**Consultation Response from KC,
Lead Local Flood Authority**

2024/92281 Land adj, 17, Whitehall Road West, Birkenshaw, BD11 2LS

Erection of 23 dwellings

Date Responded: 7th February 2025

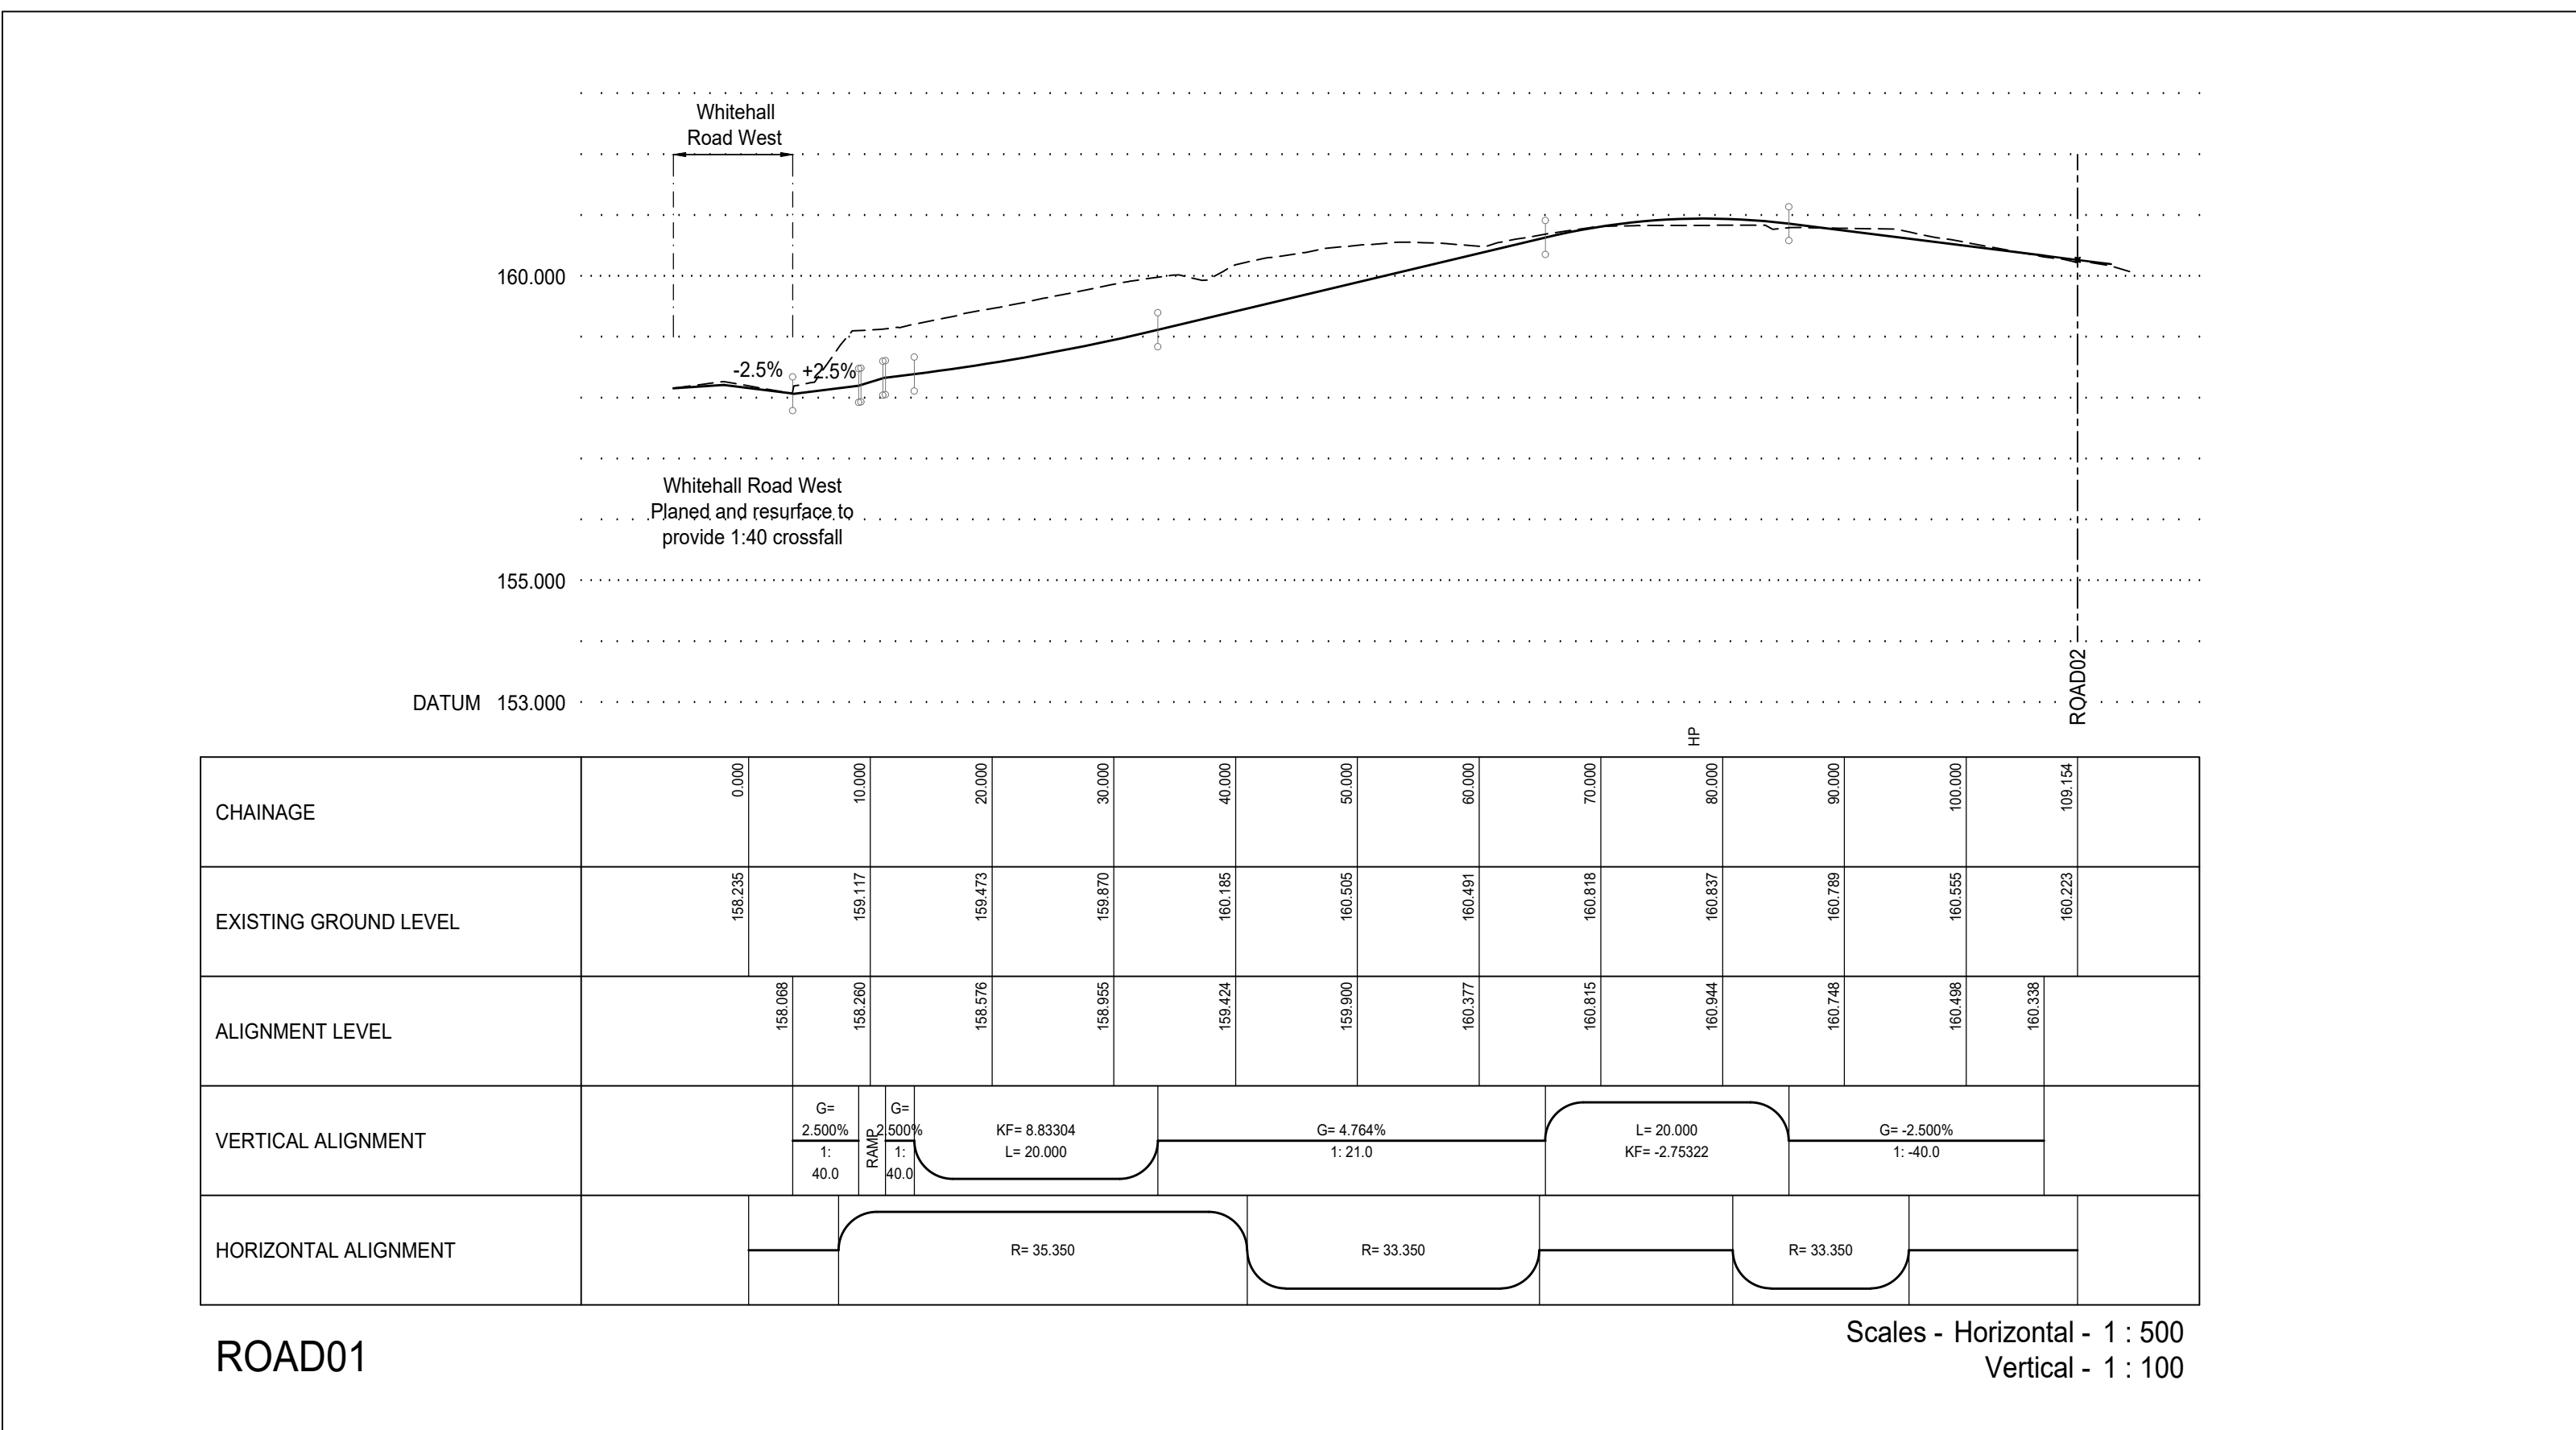
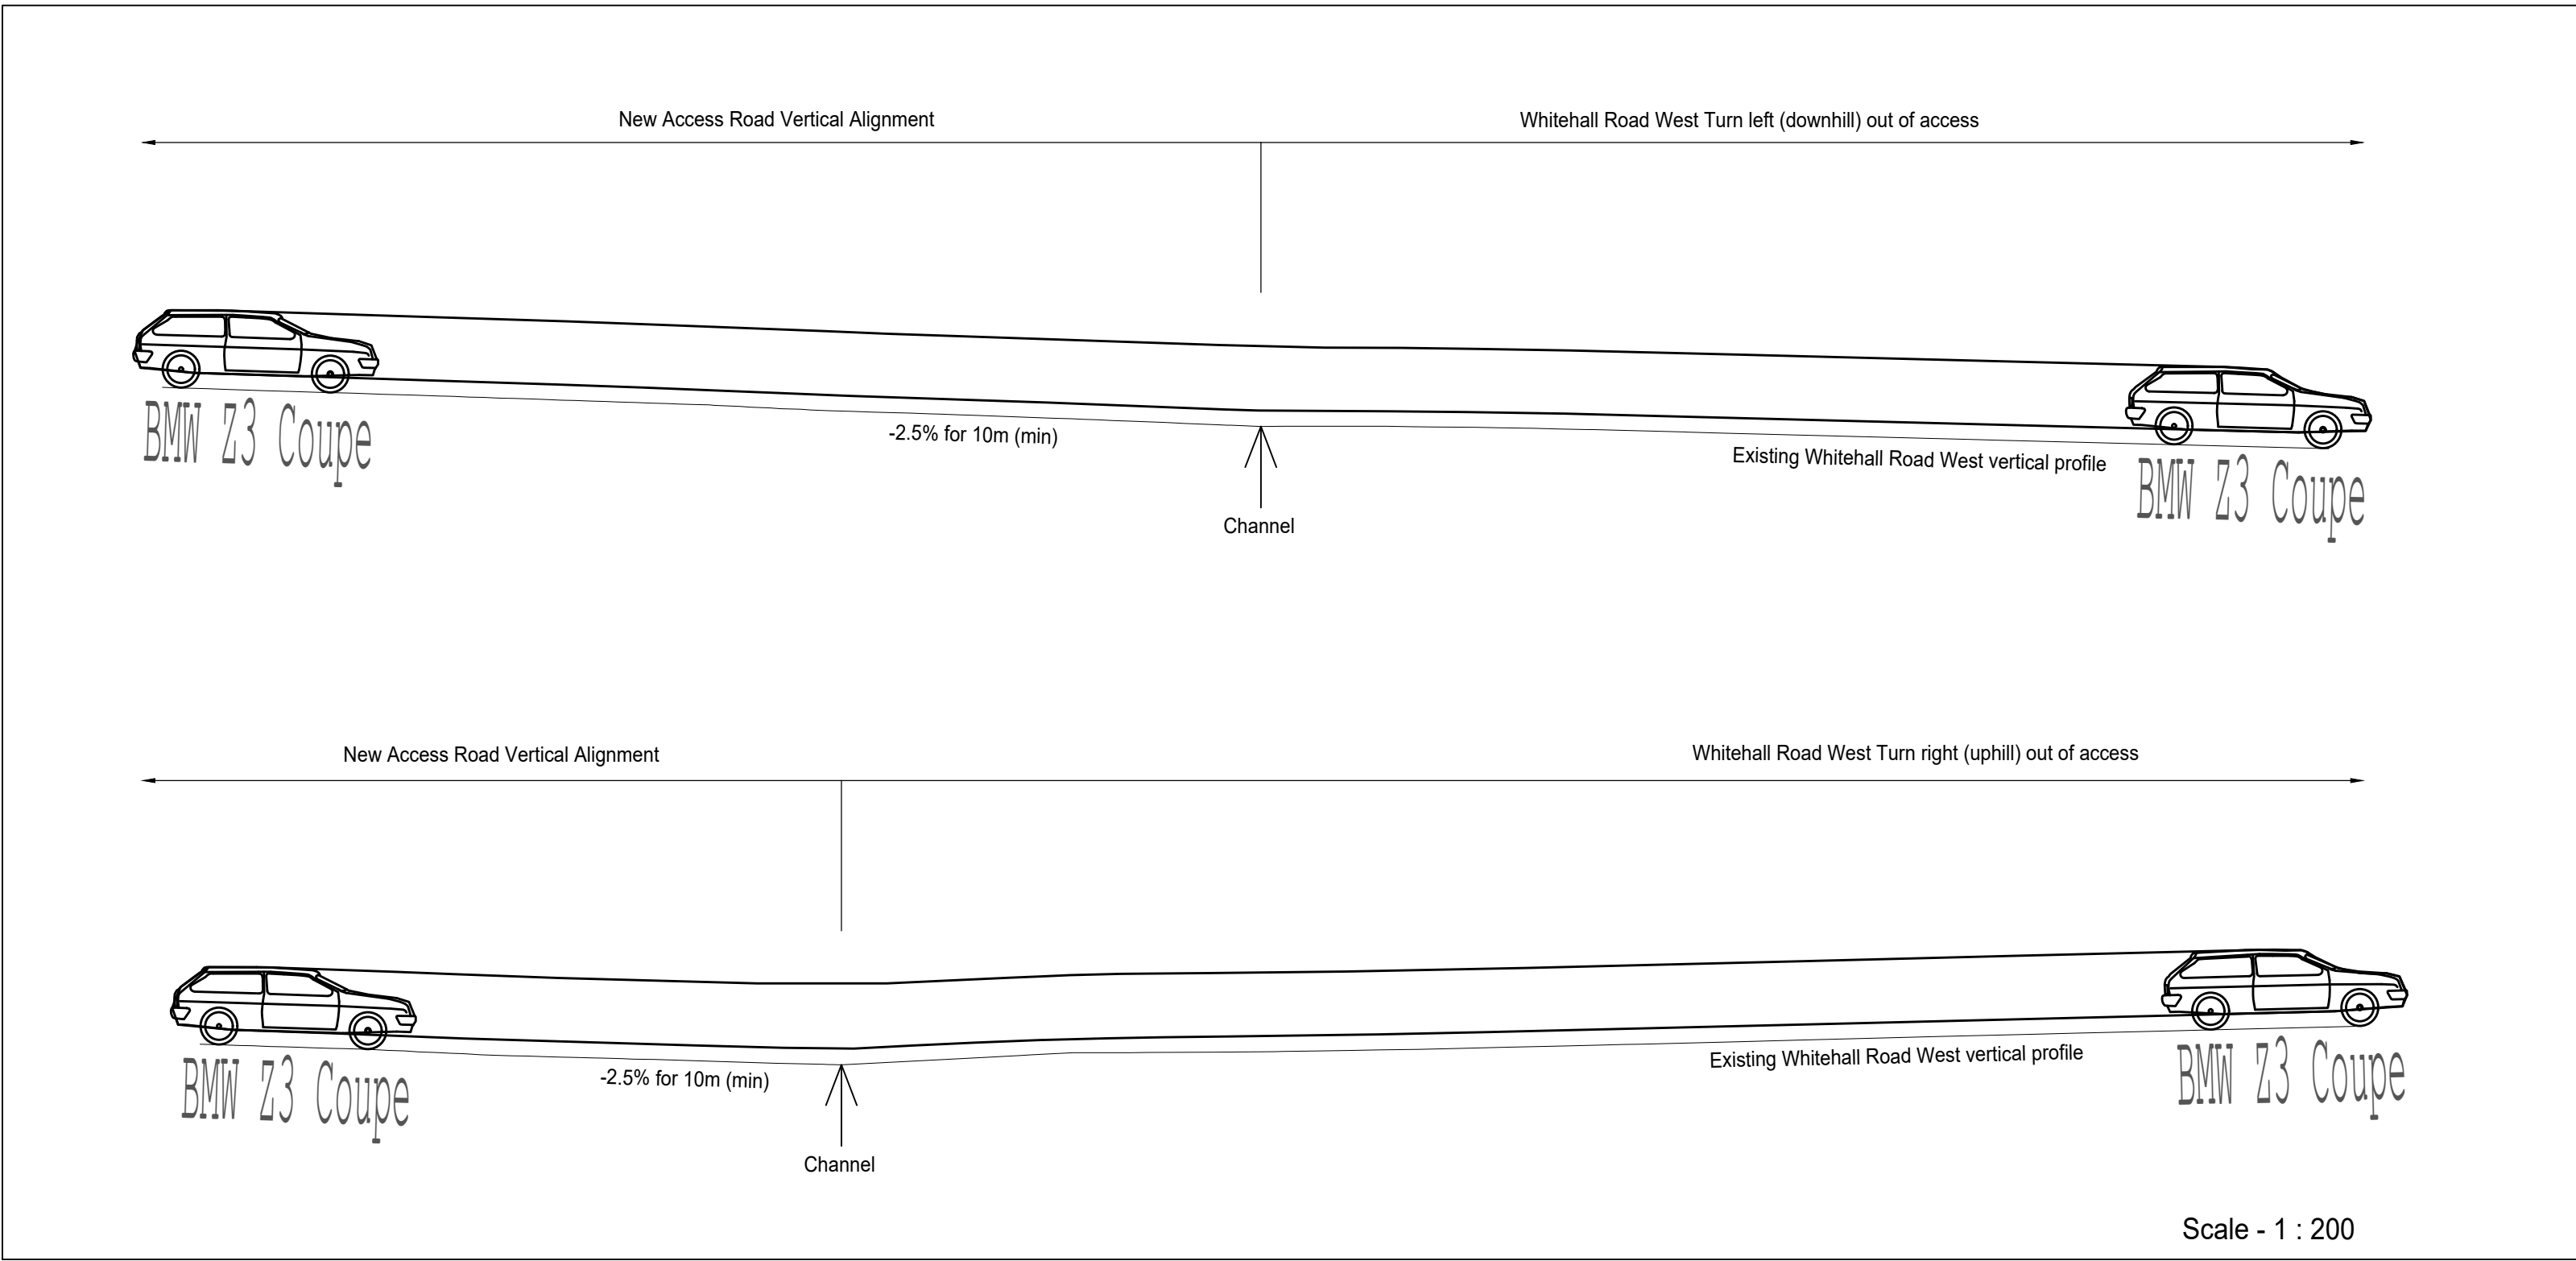
Further to our comments of 7th November, all comments still stand. Drainage layout drawing ref 23/341/500/001G has been resubmitted.

Maintenance manuals mention a Wheolite tank, not the FP McCann type noted on the drainage layout. This can be conditioned but the maintenance manual provided should be removed and not be part of any approval.

Hydraulic calculations are still showing flooding. This is not acceptable. The applicant must make sure these reflect the latest submission and tank design and include areas of existing public highway contributing to the simulation model. A plan showing hard standing contribution to each leg of sewer to cross reference with hydraulic design is also required.

Indicative flood routing is shown and is deemed to be feasible. Detailed design including contours can be conditioned.

We draw the Planning Officers attention to the use of a foul pumping station with a rising main crossing under the internal estate road. We suggest that the pump station and associated infrastructure is also included in the management company's duties of maintenance should the applicant wish the road to be adopted.
